## Application by Cleve Hill Solar Park Ltd for Cleve Hill Solar Park

### The Examining Authority's written questions and requests for information (ExQ1)

Issued on 7 June 2019

Figure 4 Project location in relation to The Swale SPA and Ramsar site [APP-026: Figure 2]

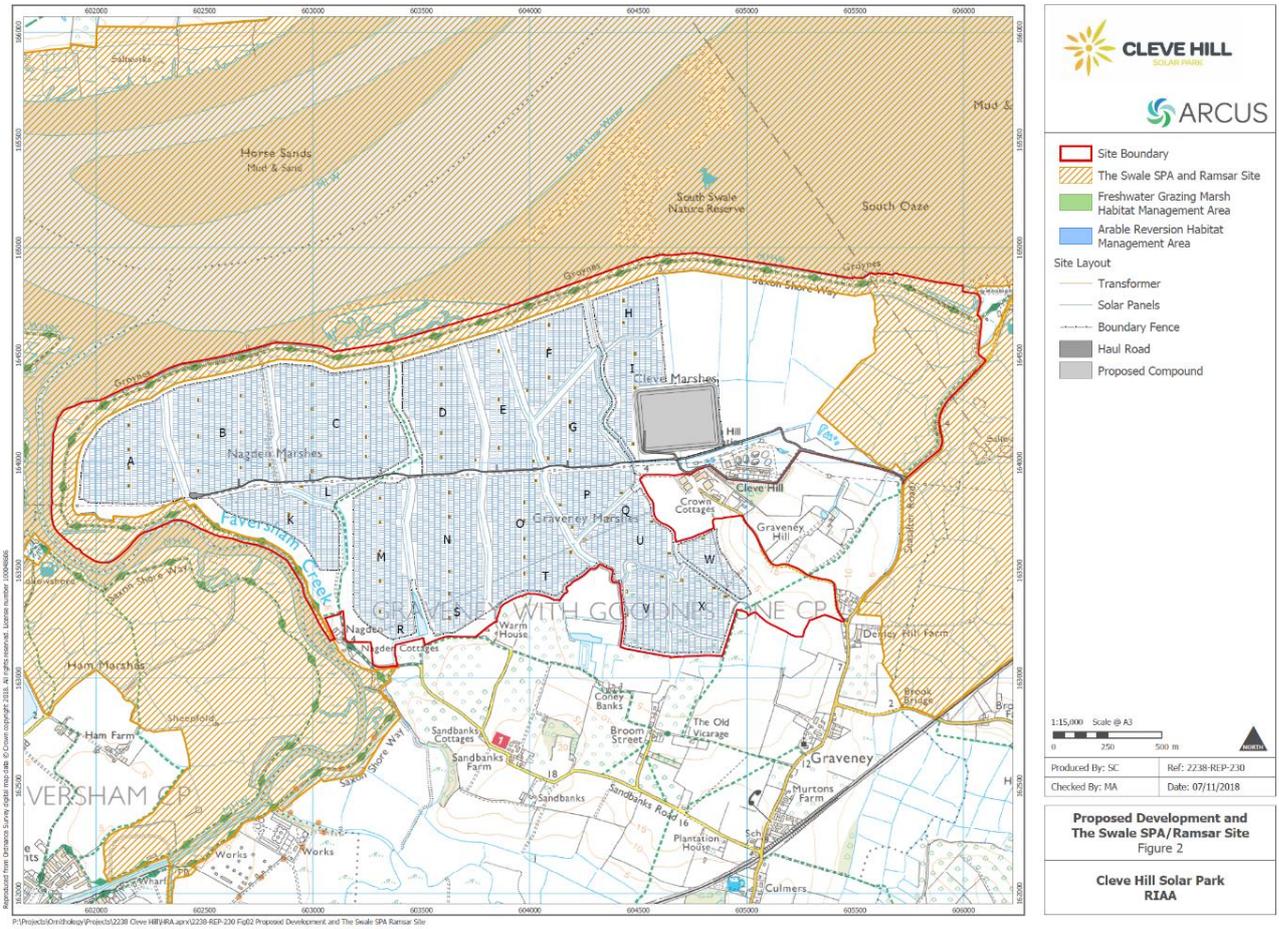
1.1.24.	The Applicant	<p>Could the Applicant clarify the location of the Arable Reversion Habitat Management Area and the Freshwater Grazing Marsh Habitat Management Area on Figure 2 of the RIAA [APP-026]?</p>
